## **KITITAS COUNTY DEPARTMENT OF PUBLIC WORKS**

**TO:** Ms. Kelly Bacon, ET I  
**COPY:** Lucas Huck, County Road Engineer  
**DATE:** May 15, 2017  
**FROM:** Mark R. Cook, Director   
**RE:** Currier Heights

Lacking any additional detail, the supplied plat drawing of Currier Heights is insufficient for Public Works to provide specific comments to Community Development. General comments concerning transportation and stormwater management are provided below for Community Development Services consideration.

SHEET CONTENTS
SITE PLAN

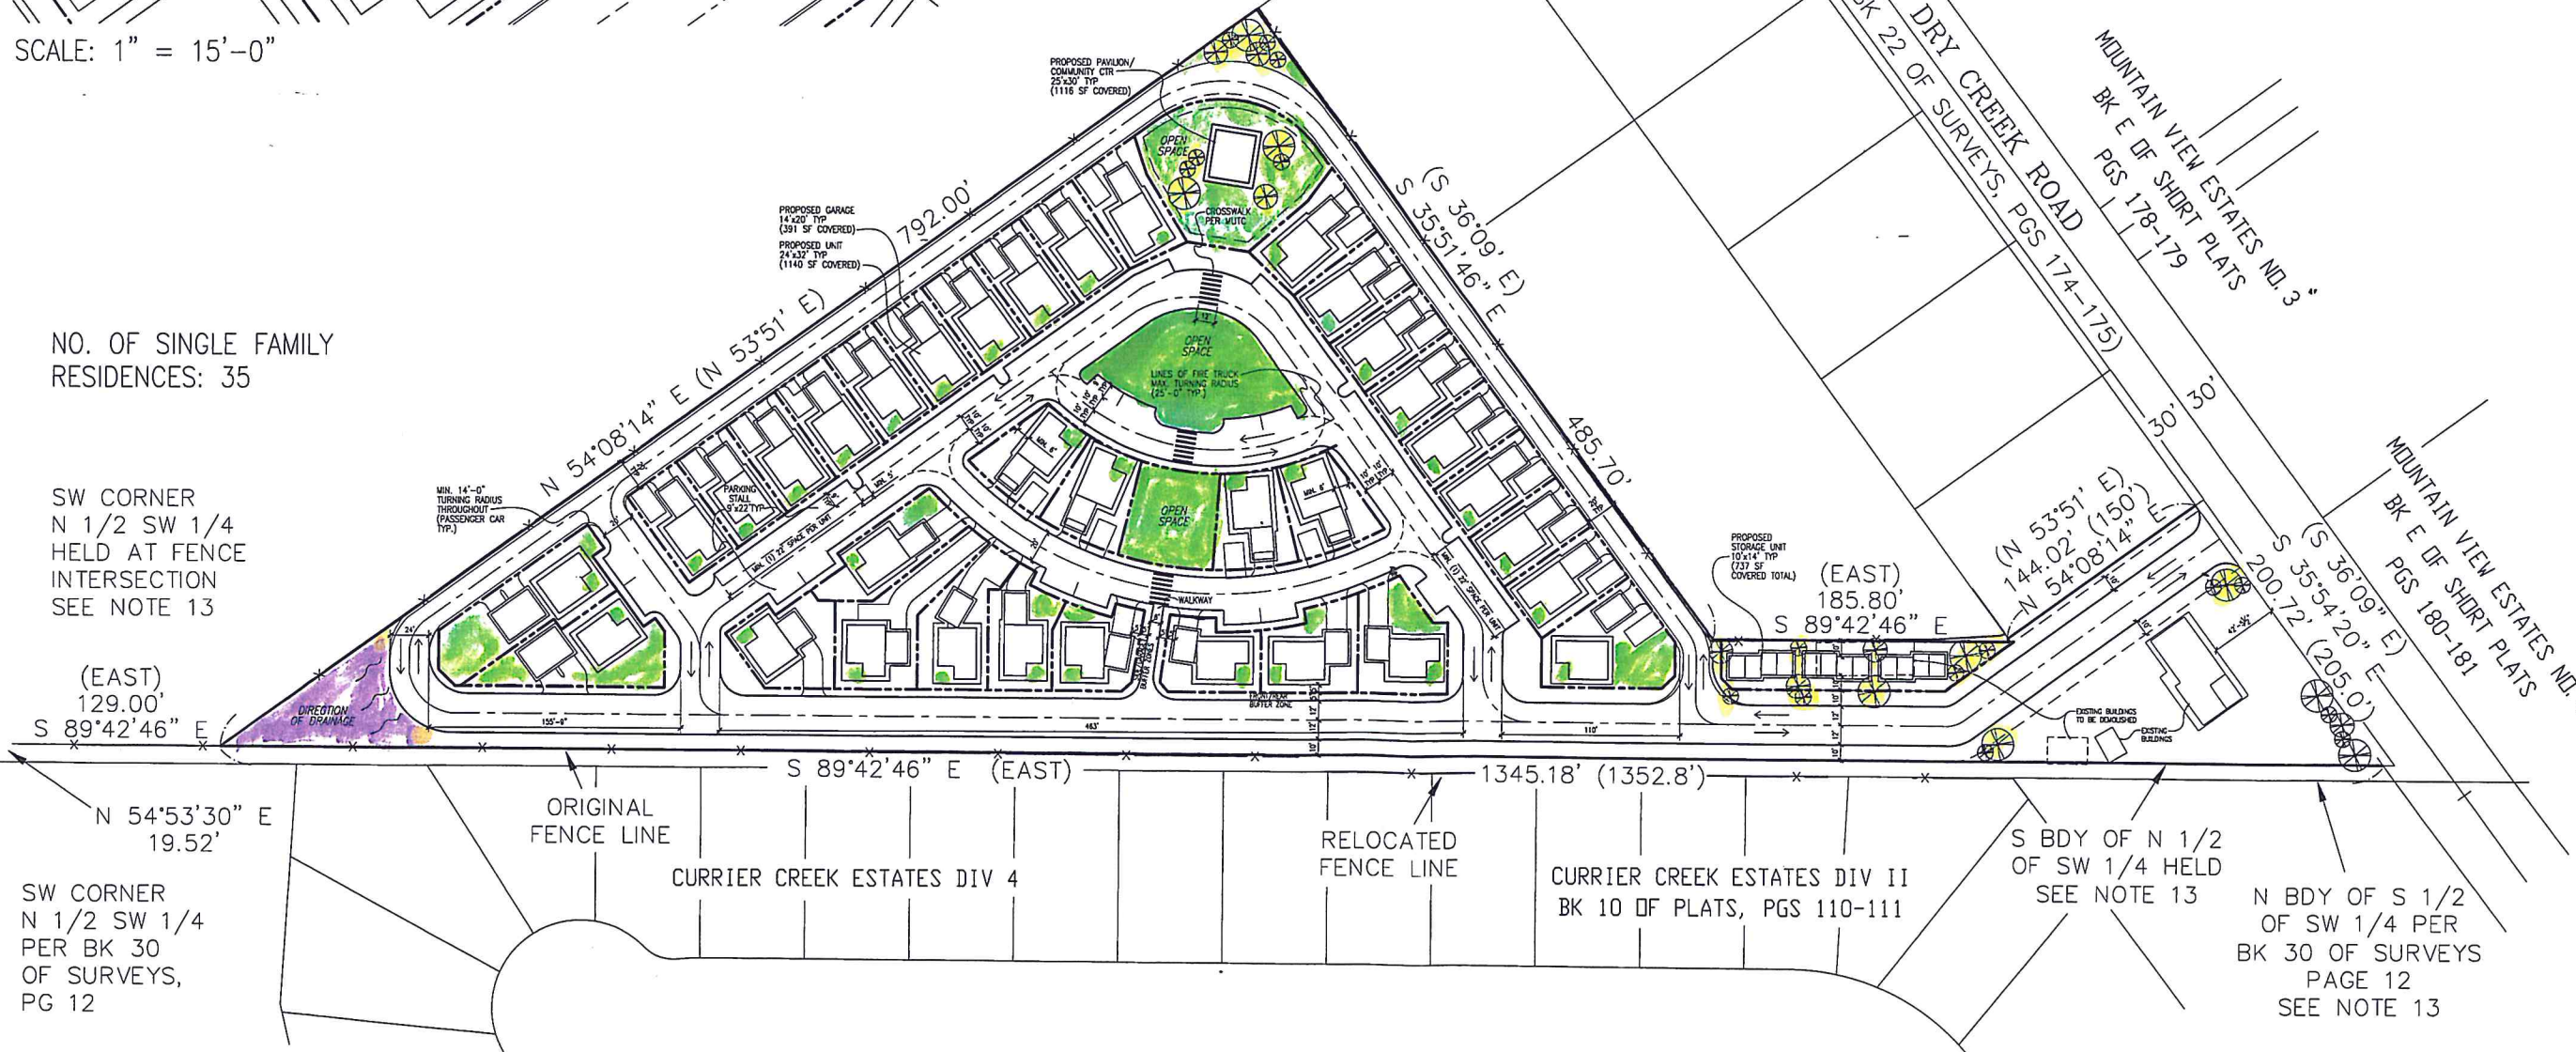
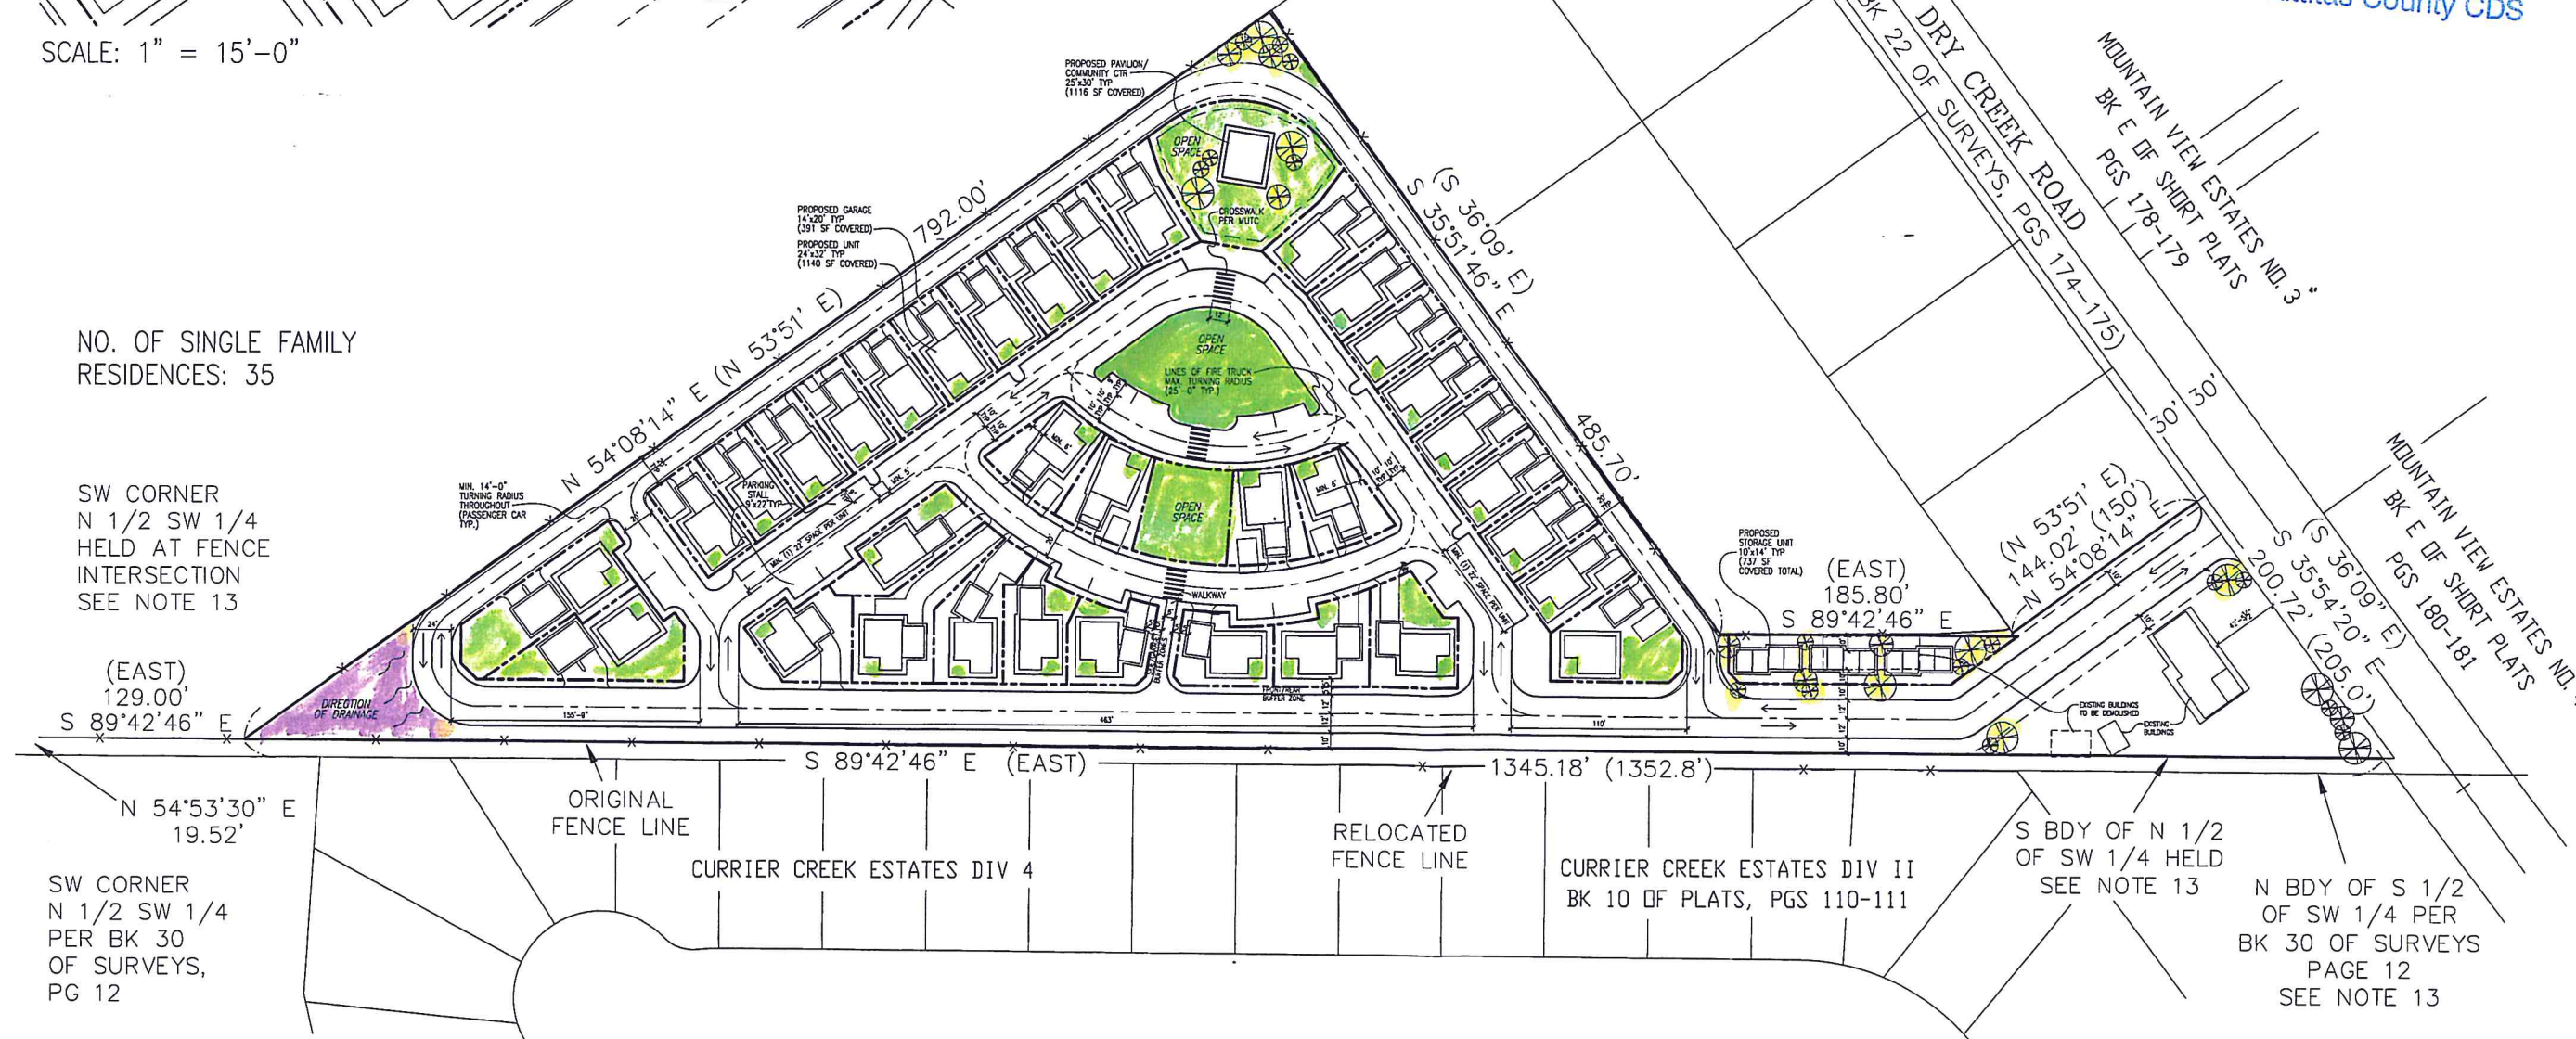
1. Kittitas County Code 12.04.040(b) (Design Criteria within an Urban Growth Area) affords final approval of the road alignment, geometry and construction requirements to the City of Ellensburg (Currier Heights). This same section references the "more stringent" of the County or City standards apply. Taken together, I interpret our code to mean the County's right of way requirements together with the wider of the two jurisdiction cross-sections with curb-gutter-sidewalk on all roadways. Given this requirement, the proposal provides far too little detail to comment further on the road proposal serving the plat. The submitted materials are insufficient for further staff review.

2. The plat is located in a known area of flooding. Two recently purchased homes in Currier Creek Estates proximate to this proposal have experienced flooding this past spring. The proposal is insufficient in detail allowing me to understand how runoff from the site will be mitigated. It is likely that no offsite discharge will be allowed from the site given known flooding in the area. The submitted materials are insufficient for further staff review.

3. I have been provided data suggesting that the site contains freshwater emergent wetlands. The provided plat map makes no notice of associated wetlands. The presence of potential wetlands further complicates the stormwater treatment and disposal scheme supporting plat development. The submitted materials are insufficient for further staff review.
